# KITITITAS COUNTY

### MEMORANDUM

TO: Community Development Services  
FROM: Public Works Plan Review Team  
DATE: August 5, 2021  
SUBJECT: SE-21-00014 Pierson

#### SEPA Application Comments

# BARB CONSTRUCTION DETAIL

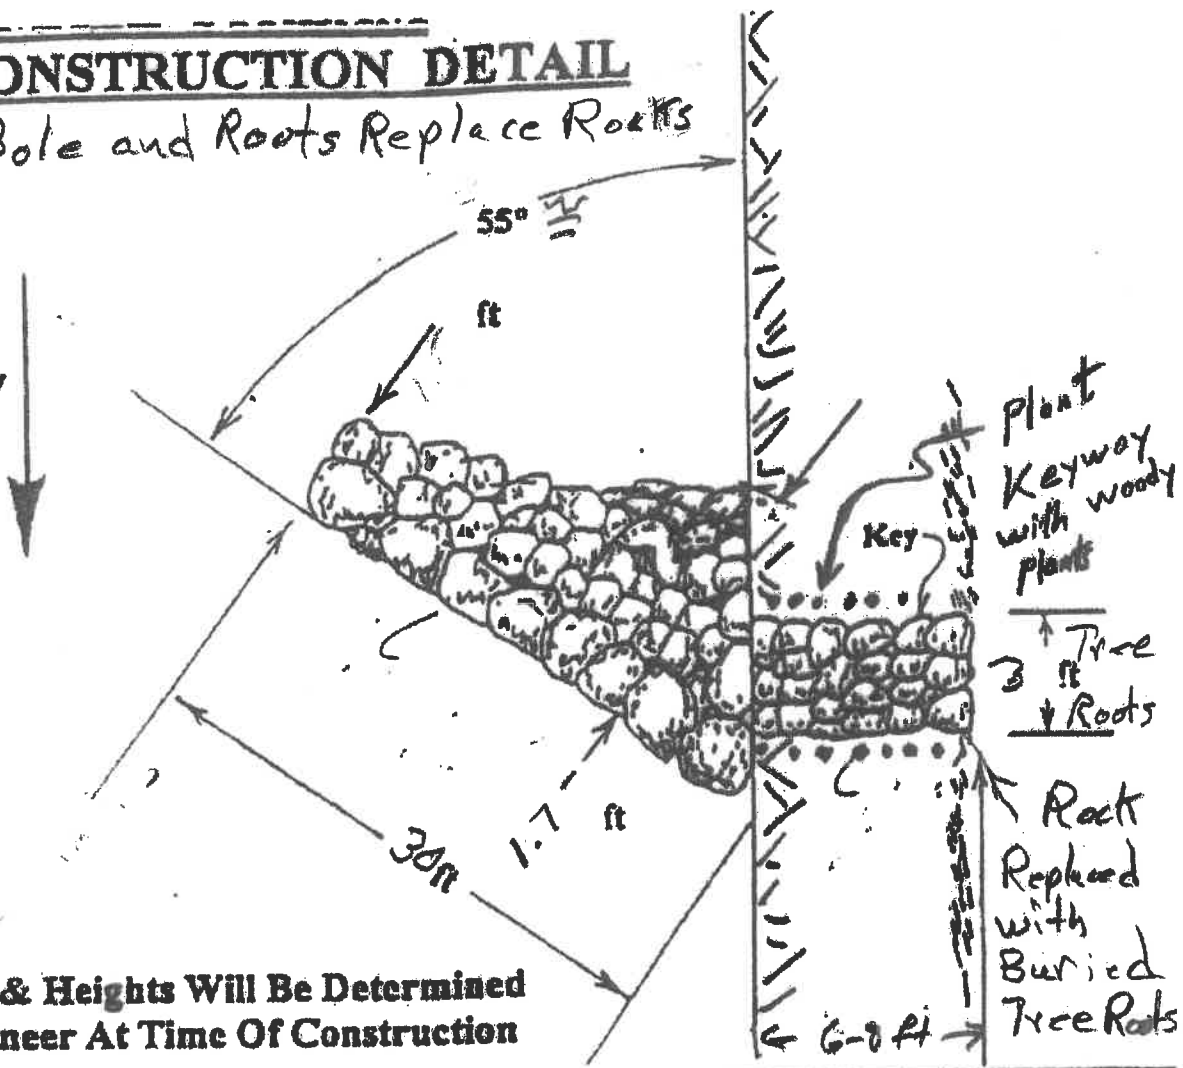
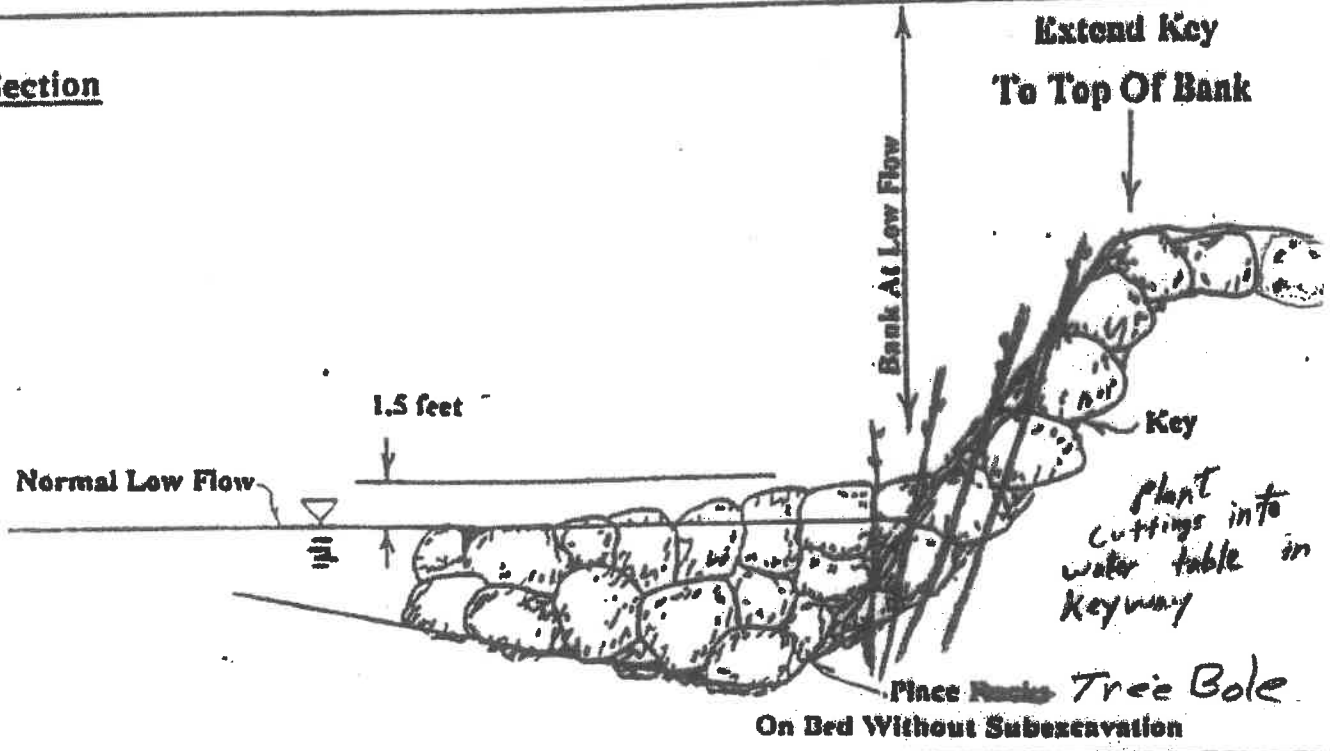
- The plans provided in the SEPA checklist are not adequate to understand the proposal. In order to evaluate this project for a floodplain development permit, the applicant will need provide additional detail about the design: (for example, how many trees will total will be used to construct the 5 barbs; clarify if 30 feet is the total length; with 22 – 24 feet of length extending into the stream channel; specify how much rock, the size of rock and the location rock will be placed; and identify excavation and backfill extents and quantities). The applicant will also need to provide technical documentation supporting the basis of design.
